SITE DEVELOPMENT PLAN
MONUMENT STEEL STRUCTURES
 BUILDING ELEVATIONS AND FLOOR PLANS
 18910 BASE CAMP ROAD
 MONUMENT, COLORADO

Floor Plans_v1-redline.pdf Markup Summary

TERRA FORMA
SOLUTIONS

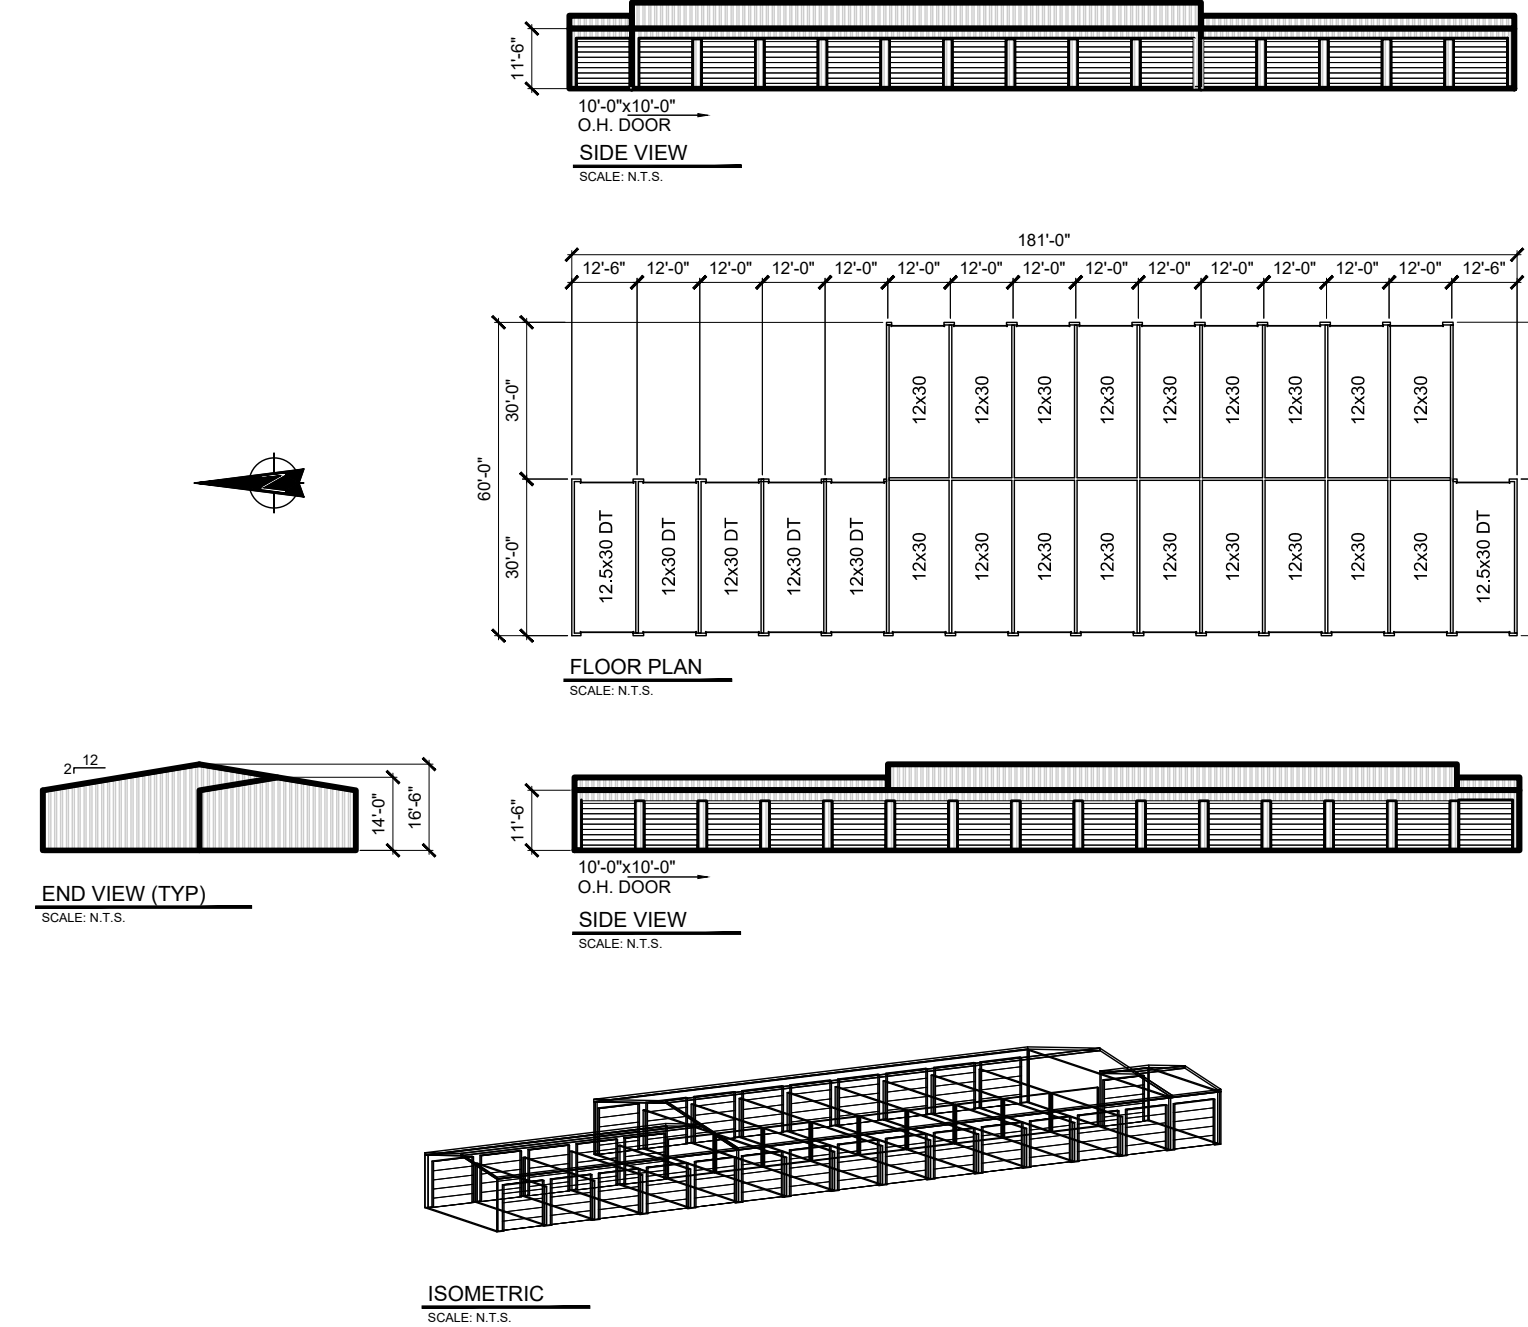
Floor plans not shown. Include dimensions
